Ms. Jennifer Wilson

Inland Rail – Albury to Illabo SSI 10055

I am writing in response to the Inland Rail Environmental Impact Study which has been released for public comment. I would like to state I object to this proposal while the proposition continues to include a plan to run the Inland Railway through the city of Wagga Wagga along existing lines.

FIGURE 7-4 INDICATIVE EDMONDSON STREET BRIDGE

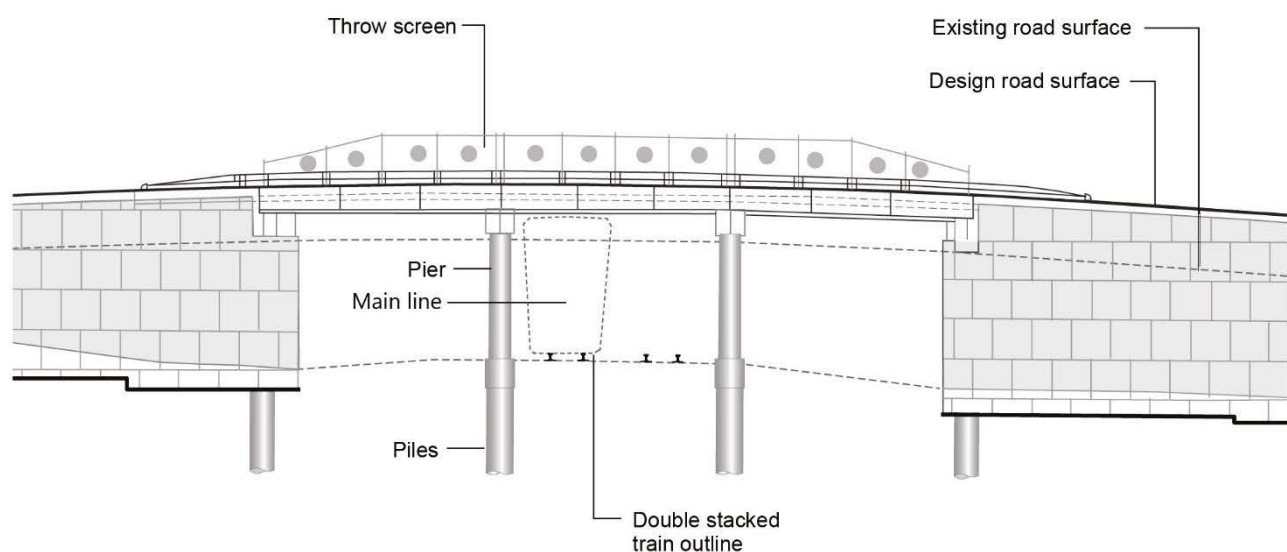
- a) The Environmental Impact Statement states there is a plan is to lift the bridge over the railway line at Edmonson Street just south of the Best Street/Edward Street

(Sturt Highway) intersections by 2.8 metres. This will result in a very steep approach over the bridge into the Edward Street/Best Street intersection. This intersection is already a very busy intersection with traffic travelling both ways across the bridge each day (including school buses) and with the additional complications of lack of visibility of the Edward Street (Sturt Highway) intersection from the southern (hill) approach and the twice daily school student foot traffic in all directions through an intersection with a national highway.

- b) Given the increase steepness of the hill rise and fall on Edmonson Street which will be caused by lifting the bridge another 2.8 metres, the line-of-sight for motor vehicle drivers as they approach the Edward Street/Best Street intersection from the south will be further reduced. There is currently no ability for vehicle drivers to see the lights at the intersection until they crest the top of the “bridge caused” hill on Edmonson Street. The problems caused by this steep descent into the extremely busy Best Street/Edward Street (Sturt Highway) intersection will raise the risk of accidents involving children and/or heavy vehicles considerably. Having personal experience of almost being “rear ended” by an overly energetic driver coming over the hill and down into that intersection from the south I can only state to you forcefully, how dangerous this situation will become with an additional 2.8 metres of height.

- c) Any attempt to “level” Edmonson Street to reduce the steep incline created by raising the bridge as it approaches the Edward Street intersection, or smooth Best Street as it leaves the intersection can only result in very poor outcomes for homeowners, pedestrians and cyclists along the Best and Edmonson streets. In addition, Erin Street would be impacted negatively with such a process.

- d) The impact of this bridge raising option, on South Wagga Public School will be considerable due to the upgrade issues, and then into the future with increased train traffic, road safety concerns, noise and vibrations. This school, which is tasked with educating the local primary aged population, will be left with a future of a national highway running along its southern boundary and increased rail traffic running along its northern boundary. Hardly an improved outcome for a school which already has traffic noise, road safety, vibration and air quality challenges.

FIGURE 7-6 INDICATIVE PEDESTRIAN BRIDGE

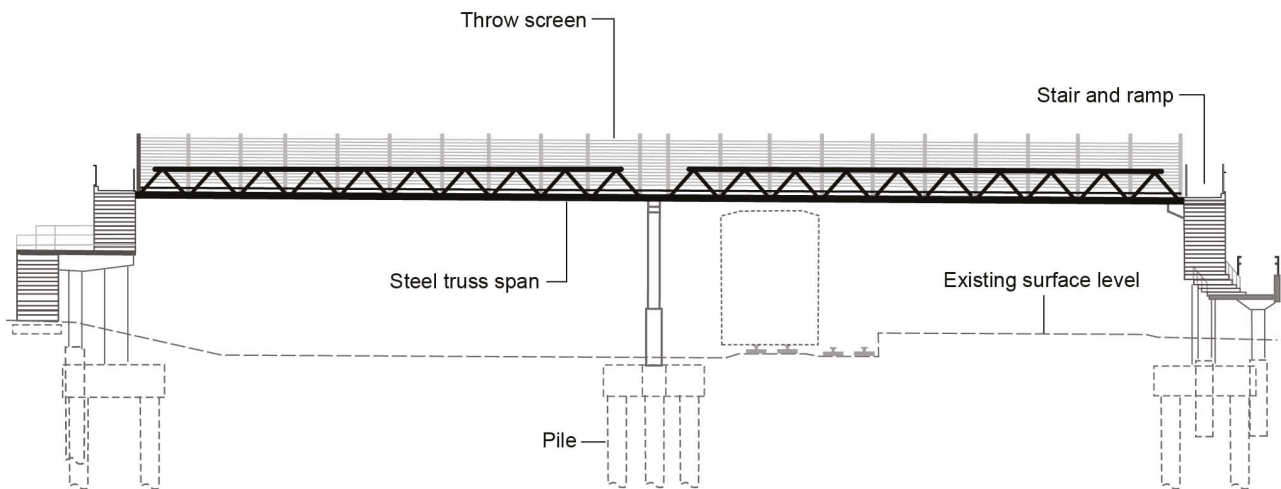
5. The plans to upgrade the footbridges are also fraught. Problems with the casual dismissal of heritage related issues, together with the steep inclines and declines of the resulting bridges for mothers with prams, toddlers on bikes and disabled and elderly people on foot or in a

chair or on a scooter have not been addressed to the comfort of local people. Access to the educational services and to city on foot will be severely compromised.
